APPLICATION NO. 05 DR B00549	PROJECT NO. 1003811
PROJECT NAME Bol AIR Lt GA-7A BK 3	
EPC APPLICATION NO.	
APPLICANT / AGENT MORRIS Gutierrez	PHONE NO. 881-7833
ZONE ATLAS PAGE H-17	
(SDP for SUB), (SDP for BP), (FINAL PLATS), (MASTER DEV PLAN), (IR), (AA)	
ONE STOP COMMENT FORM LOG

Subdivision Name: BEL-AIR SUBDIVISION LOTS 6A &7A

RE: Lots 6 & 7, Bel Air Subdivision/ sketch

PLAT OF  
**LOTS 6-A and 7-A**  
**BLOCK 3**  
**BEL-AIR SUBDIVISION**

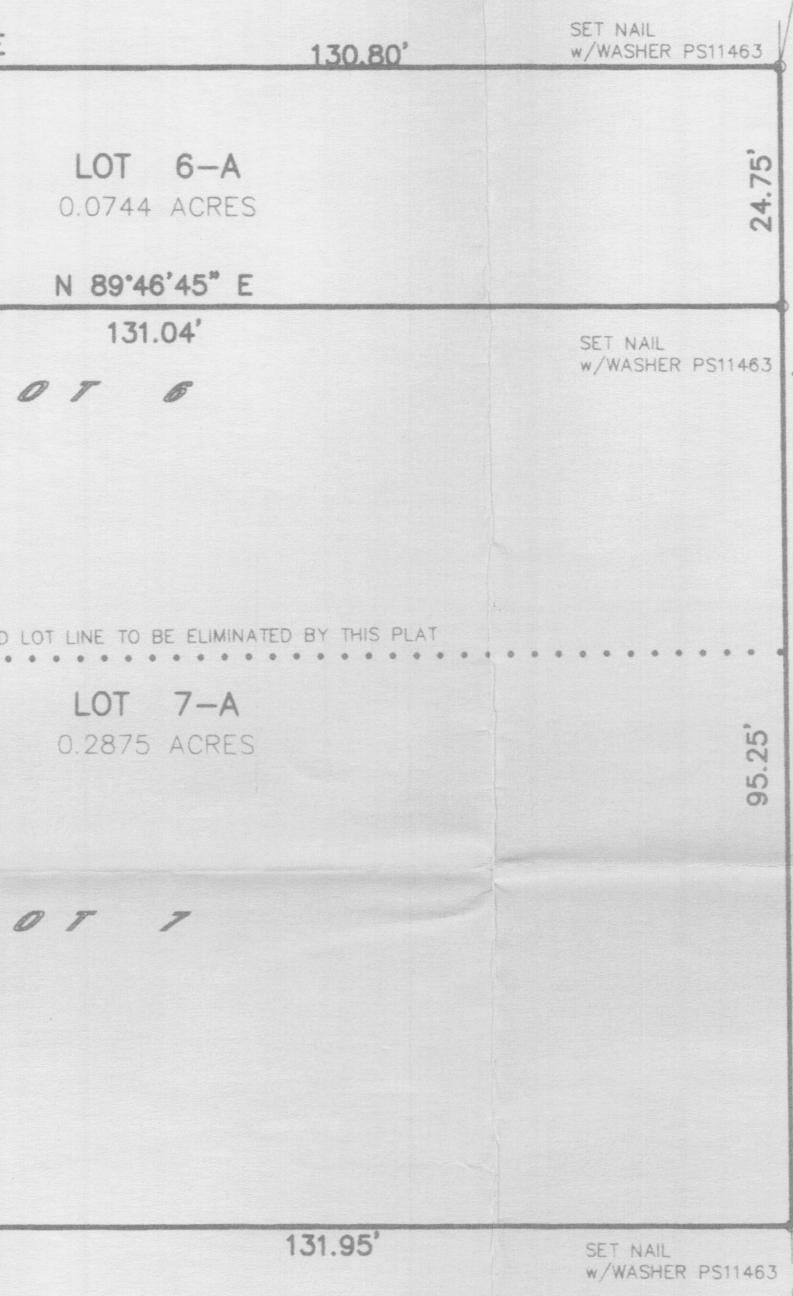
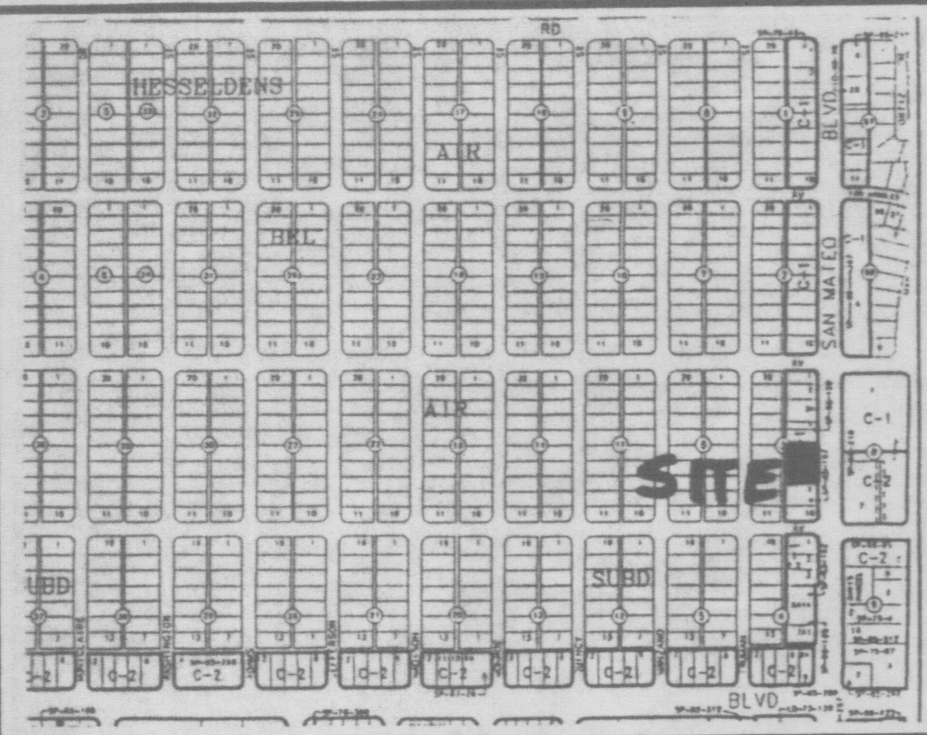
TRANSPORTATION DEV (505) 924-3990		
PLANS DISAPPROVED <i>WG</i>	DATE <i>4-4-05</i>	DATE
PLANS APPROVED <i>WG</i>	DATE <i>4-8-05</i>	DATE
COMMENTS:		
<i>THE RECIPROCAL AGREEMENTS NEED TO IDENTIFY MAINTENANCE & BENEFICIARIES RESPONSIBILITIES (NOTE #10)</i>		
<i>DR. NB</i>		
<i>Corrections made to mylan 5-8-05</i>
